**Emailed March 25, 2021**  
DRB Comments for Meeting on 3/31/2021

**RE: DRB COMMENTS for PR-2020-005210**

**(City of Albuquerque Regional Sports Complex)**

SI-2021-00303

POND 5S RUNDOWN ENLARGED PLAN VIEW

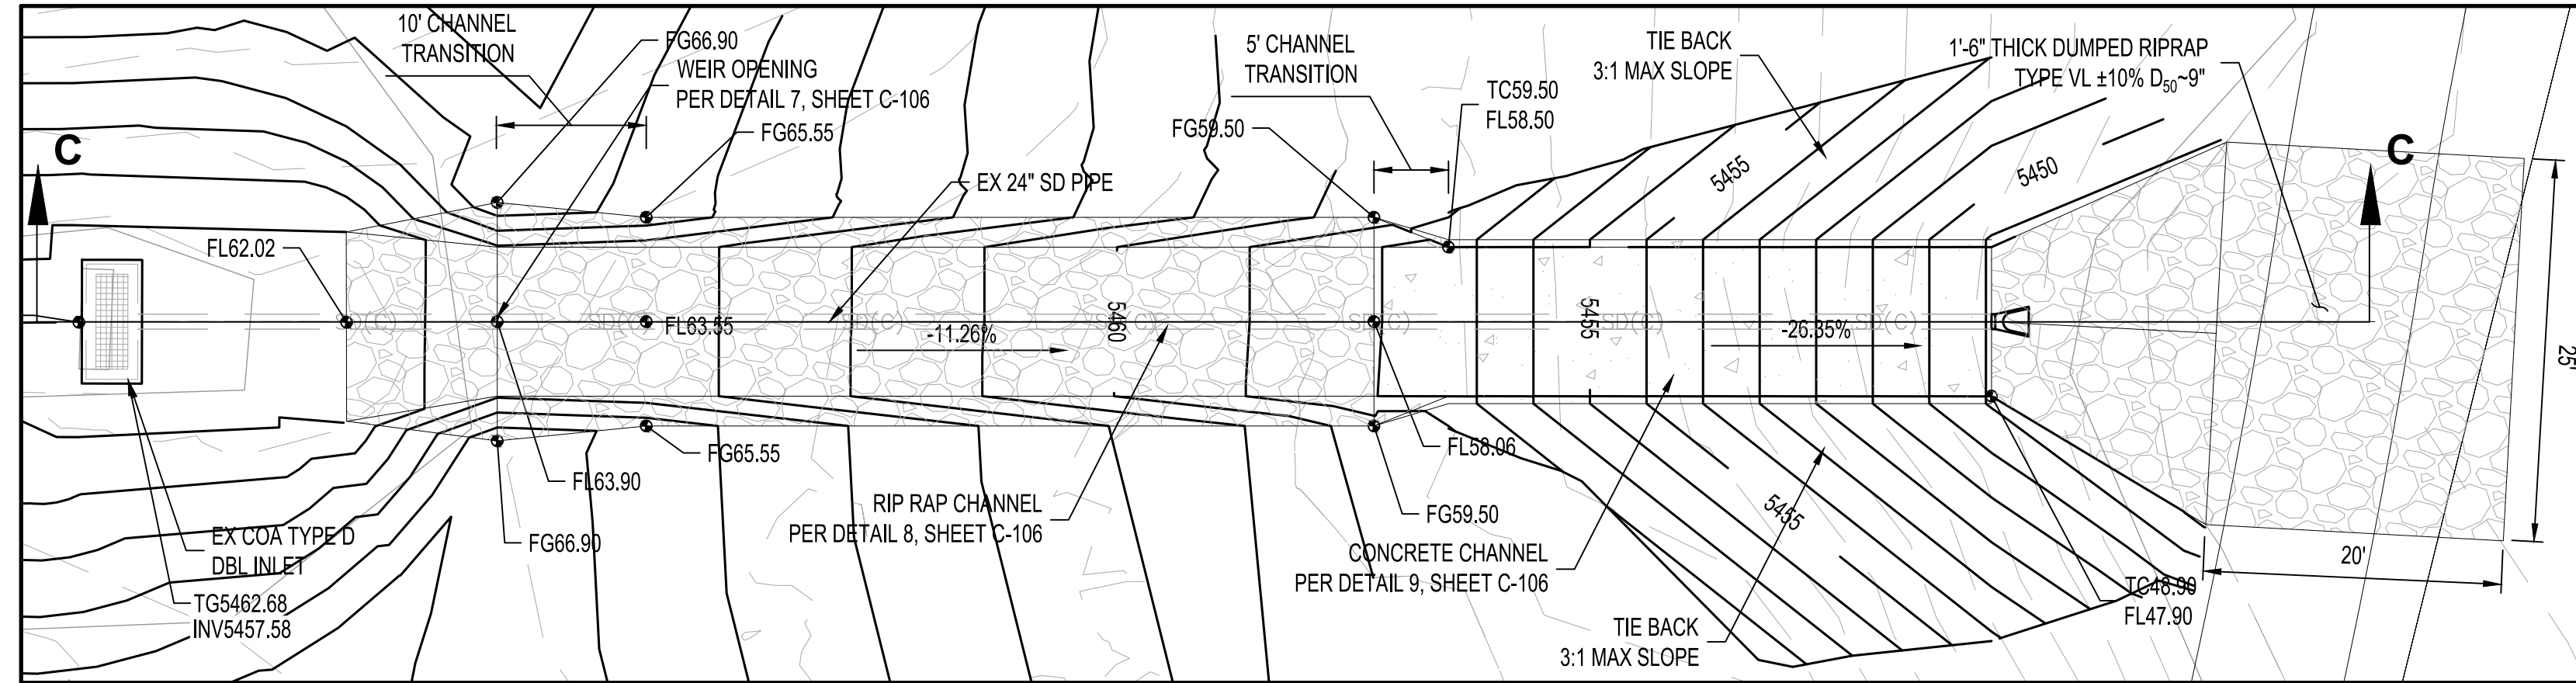
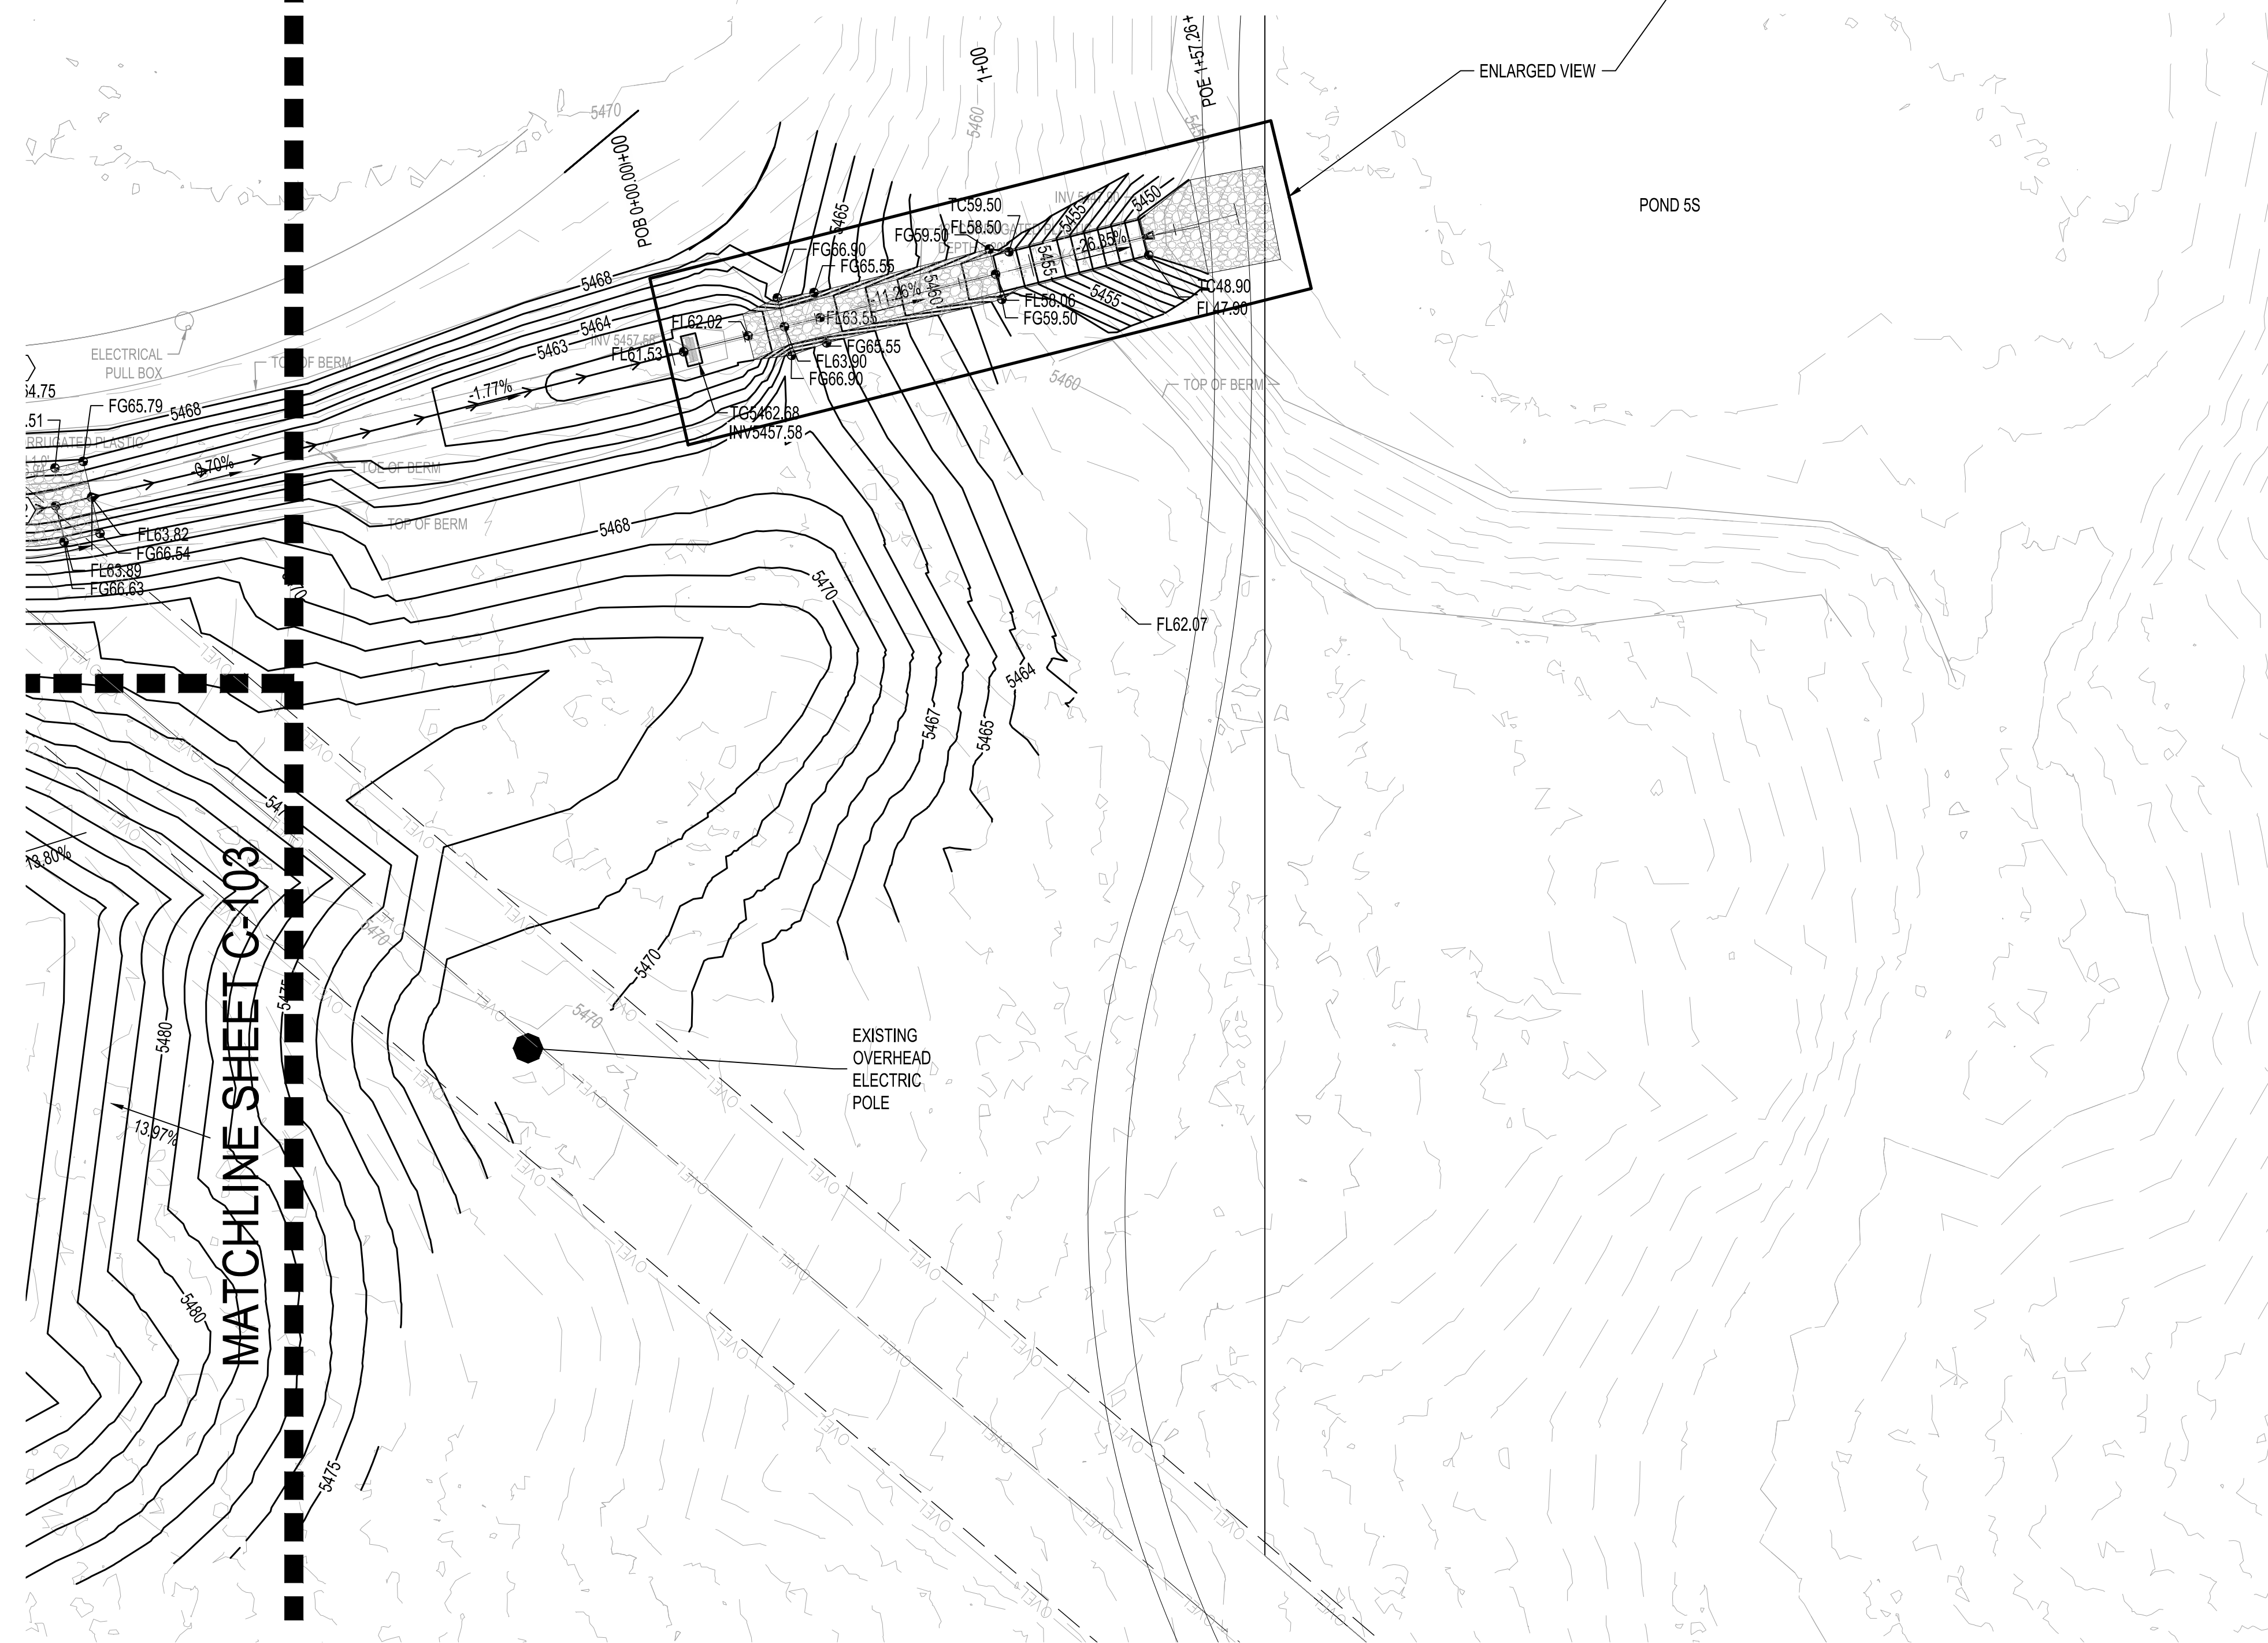
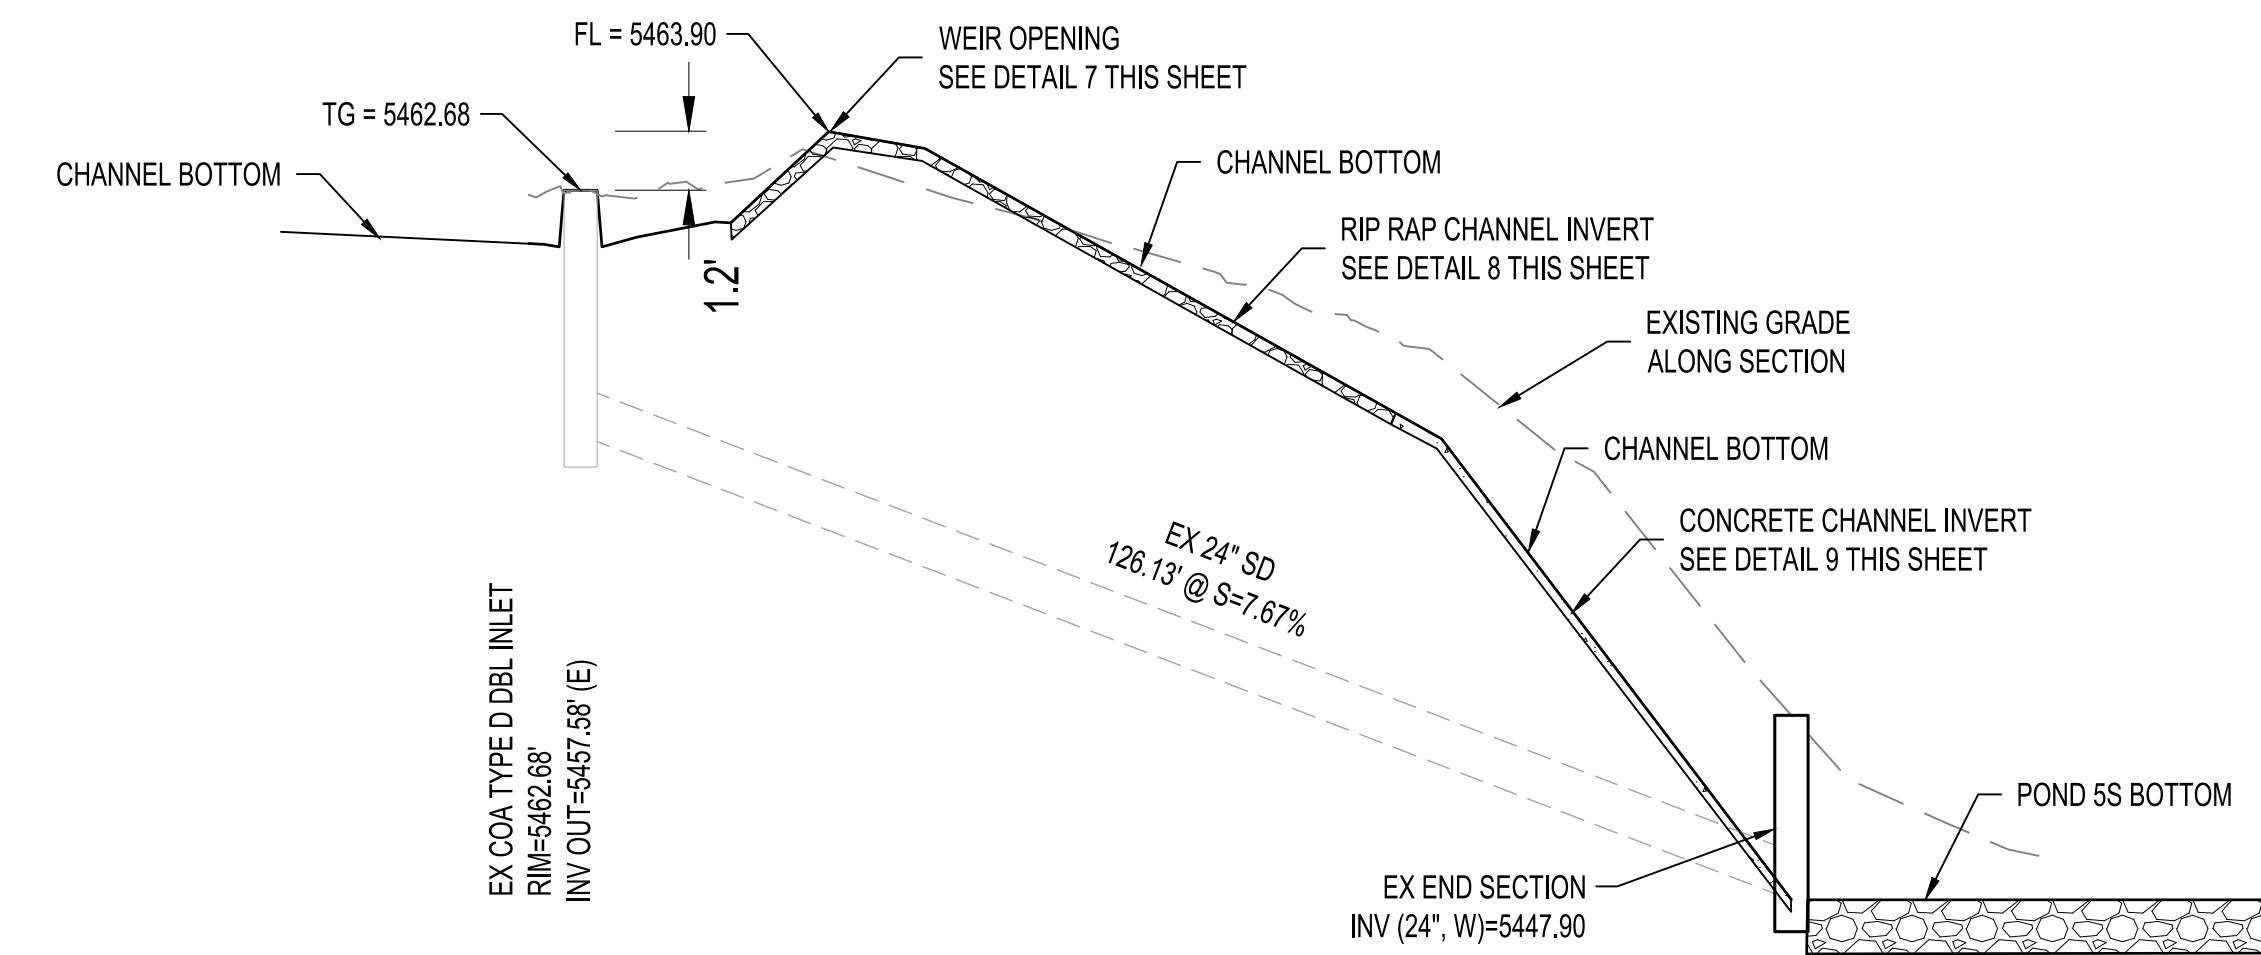
- The contractor will be required to get a Temporary Construction License from AMAFCA for the work in Pond 5S.
- The Pond 5S Rundown Section will need to ensure that it is constructed to maintain AMAFCA access.
